DRB Application No.: *11DRB-70308*

Project Name: *Paris Addition*

PROPOSED EVENTS CENTER AT 1510/1512 FIRST STREET, ALBUQUERQUE, NM

OFFICIAL NOTIFICATION OF DECISION

SITE PLAN AND PROJECT DATA

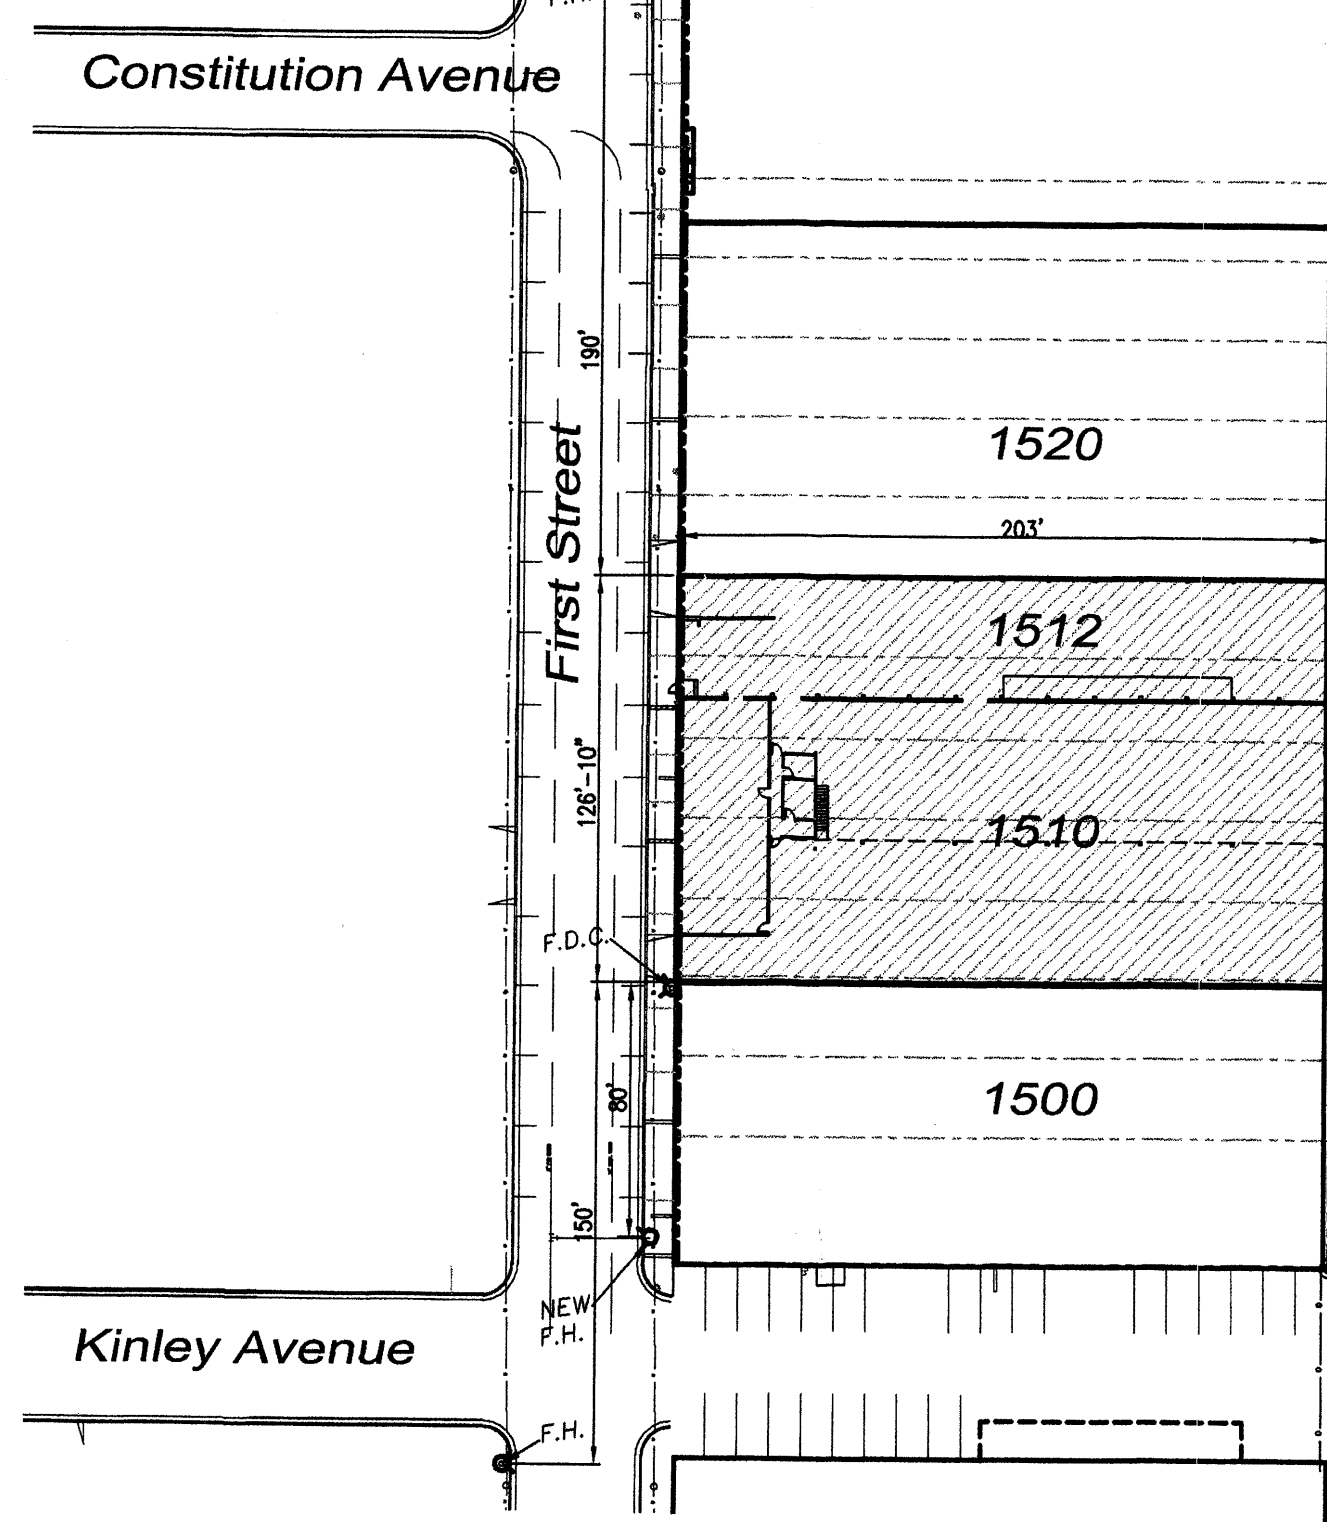
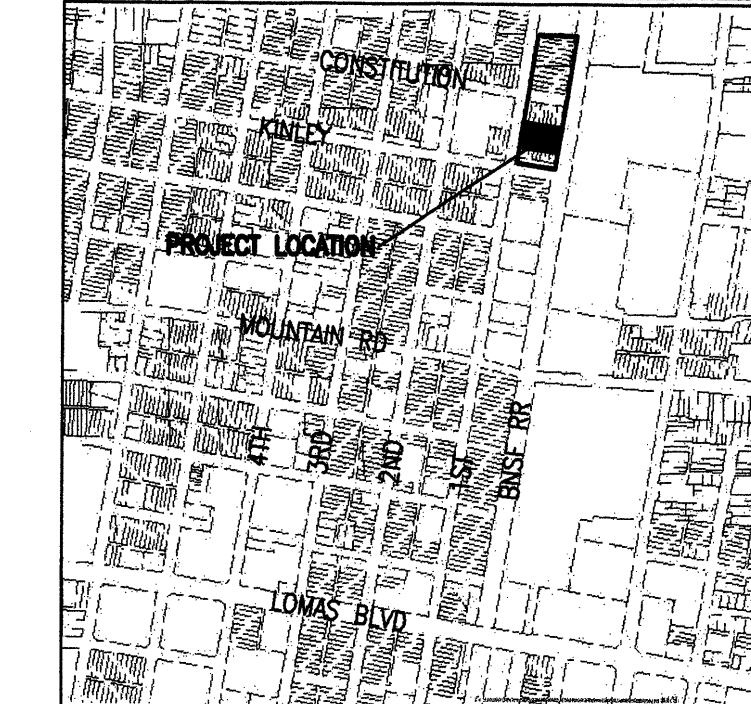
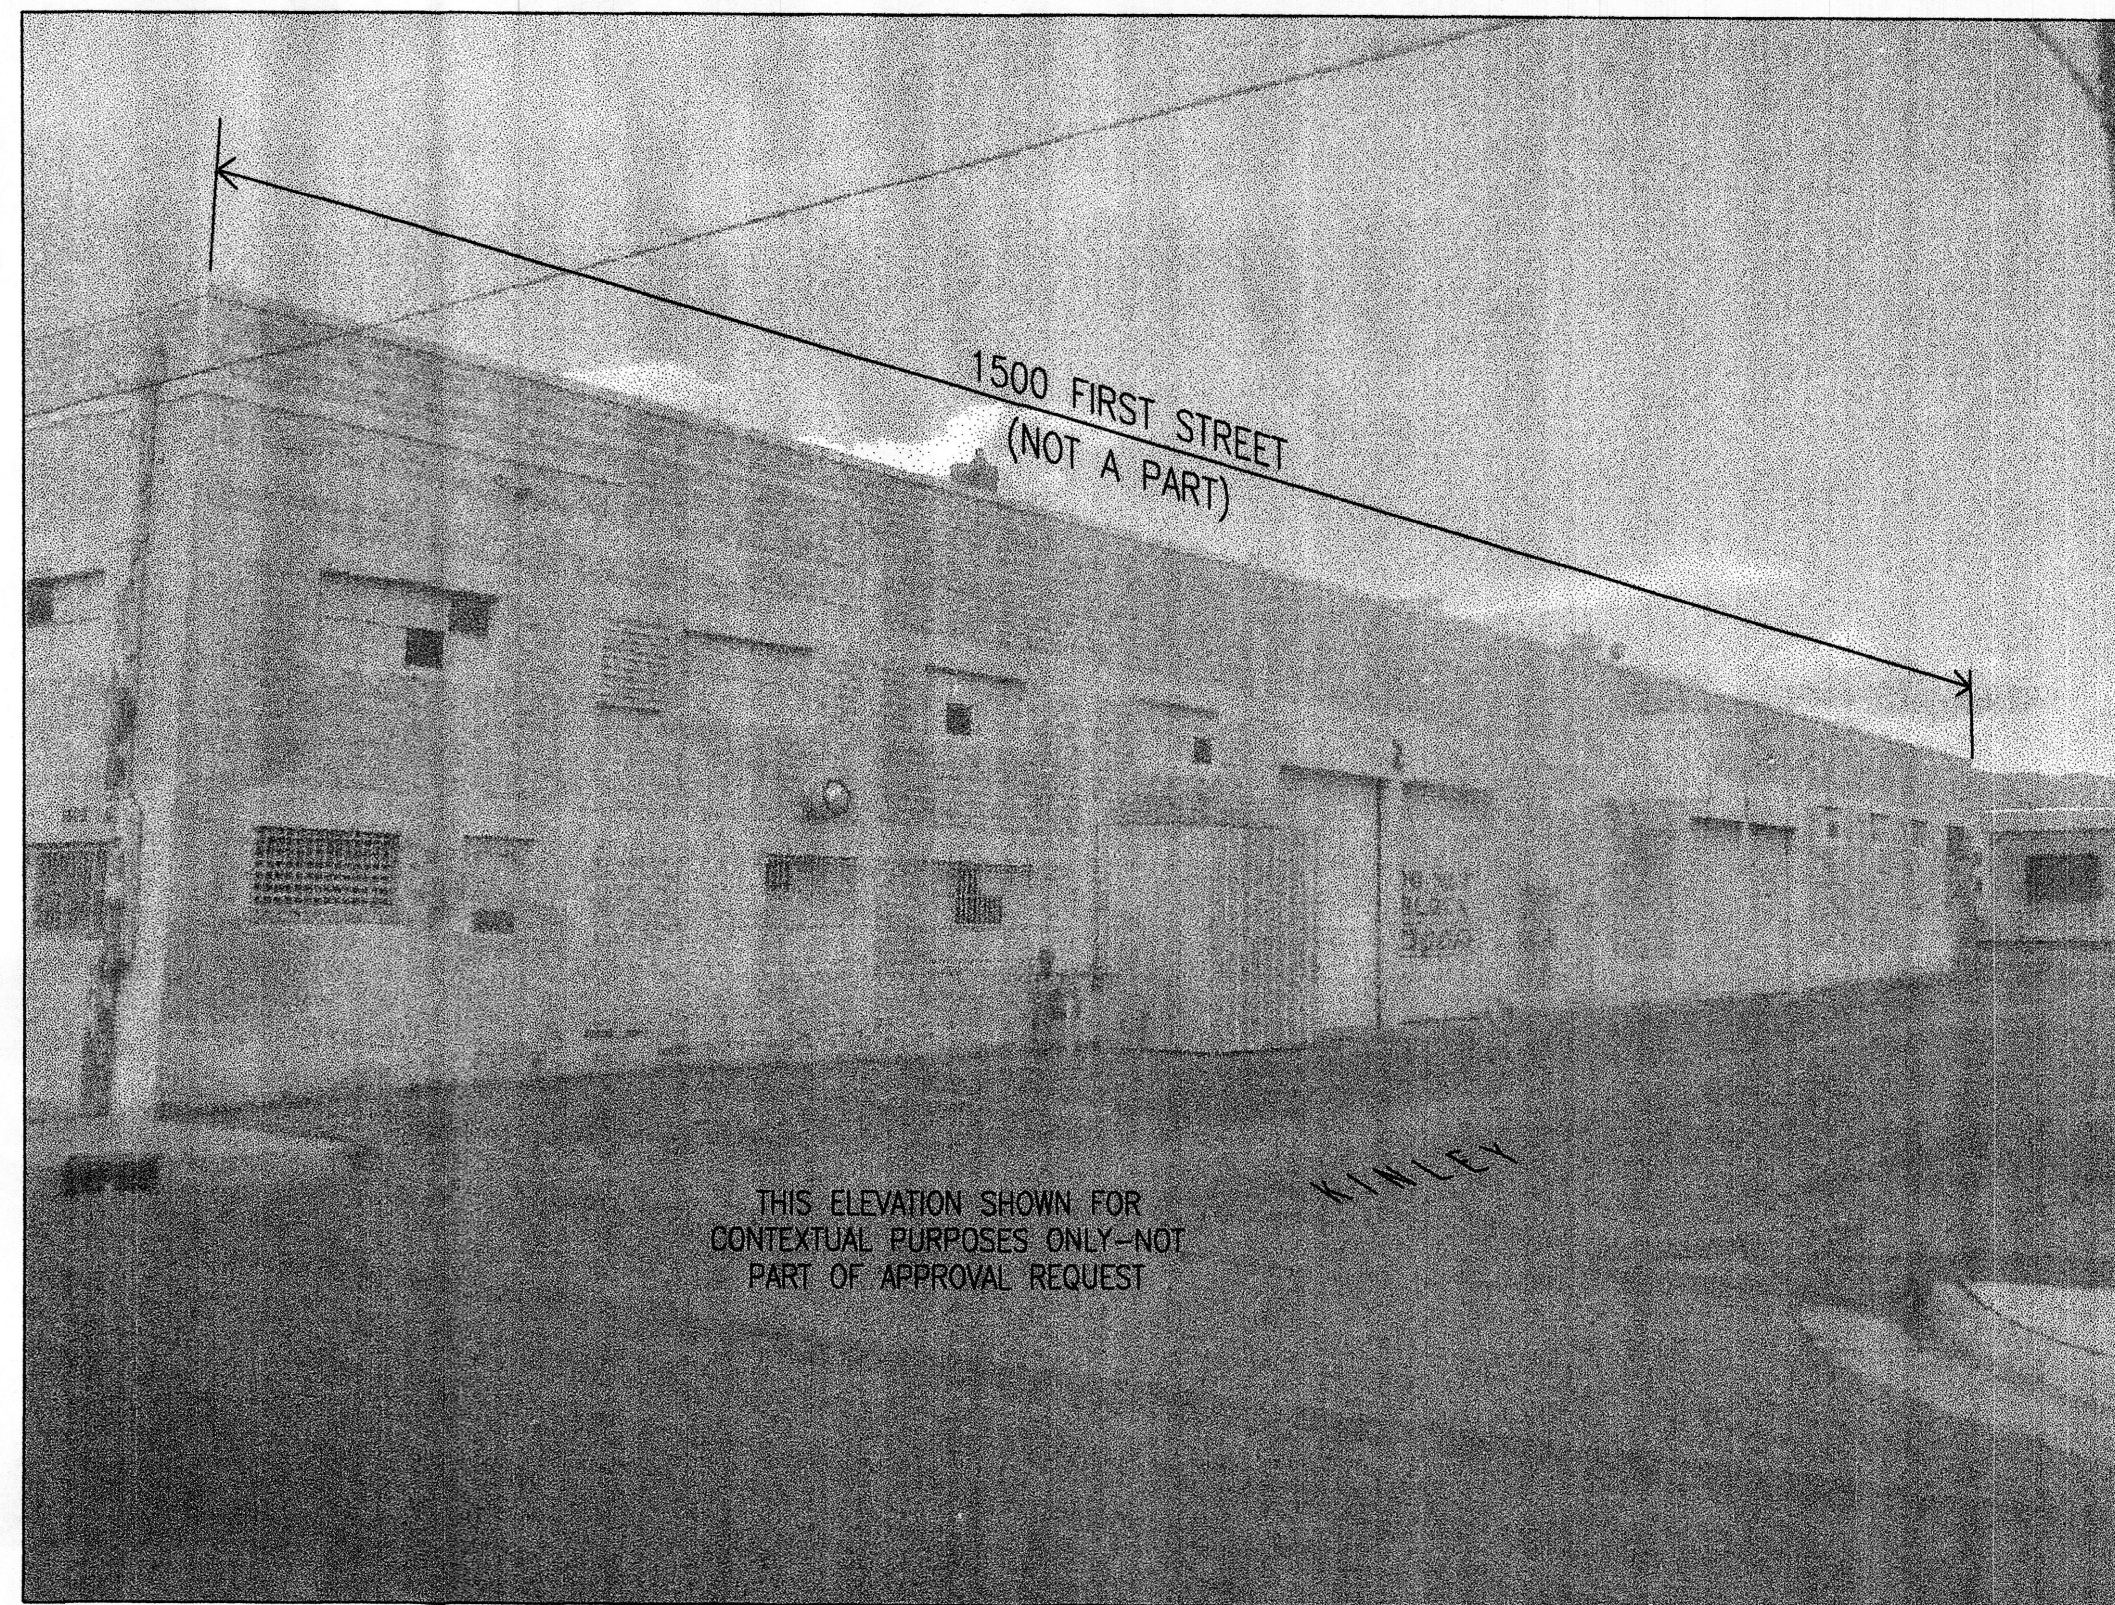
4. The maximum building height, minimum building setback and the maximum floor area ratio (F.A.R.) shall be added to the site development plan.

5. Dimensions of the building, doors and windows as well as the correct zoning descriptor, SU-1/M-2 Uses and Events Center, and the definition for Events Center shall be added to the site development plan. The definition for the Events Center shall be as follows:

6. A note shall be added to the site development plan that states: “The Events Center operational hours will be limited to after 5:00 pm weekdays, weekends and holidays for events greater than attendance of 75 people. The Planning Director is authorized to reduce the maximum size of events during business hours if a determination is made that the Events Center is creating a parking problem.”
7. The maximum capacity of the Events Center shall be 300 people and shall be added to the site development plan as a note.

Condition 4: The maximum building height, current building setback and current floor area ratio have been added to the Site Data and revised on the Site Development Plan.

Condition 5: Dimensions for the existing building doors and windows have been added to the Site Development Plan and also to the Building Elevations. The correct zoning description and definition of "Events Center" as printed in the notice of decision have been added to the Site Data on the Site Development Plan.

Condition 6: A note describing the operational hours and event size as printed in the notice of decision has been added to the Site Data on the Site Development Plan.

Condition 7: A note limiting the maximum occupant load to 300 has been added to the Site Data on the Site Development Plan.
